**From:** <liz-matt@bigpond.net.au>  
**To:** <plan\_comment@planning.nsw.gov.au>  
**Date:** 1/11/2012 11:43 am  
**Subject:** Submission re Epping to Thornleigh 3rd Track Project  
**Attachments:** 3rd Rail track Project Submission - M Grieves.pdf

Epping to Thornleigh Third Track Proposal. Application number SSI 5132.

Figure 5.6 Cross-section and elevation - New Cheltenham Station concourse building
Note: Indicatively added to future design

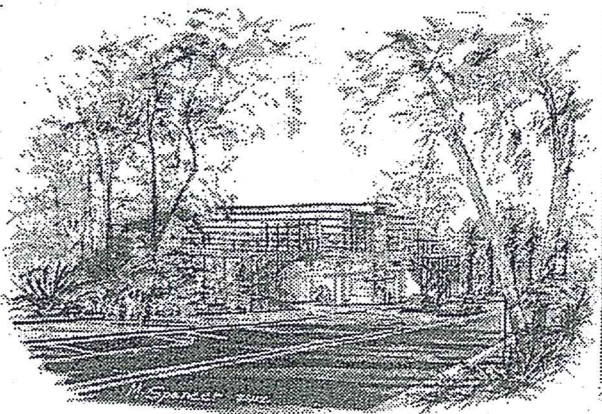
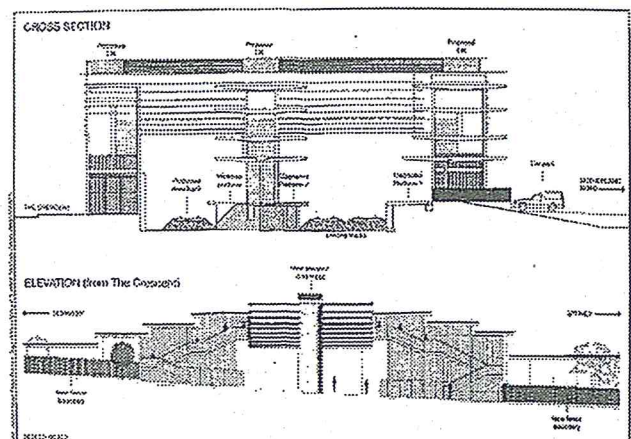
- The proposed redevelopment of Cheltenham Station shows no regard for the HCA. The visual impact of the proposed 13m high glass and steel concourse is totally unacceptable in this HCA.
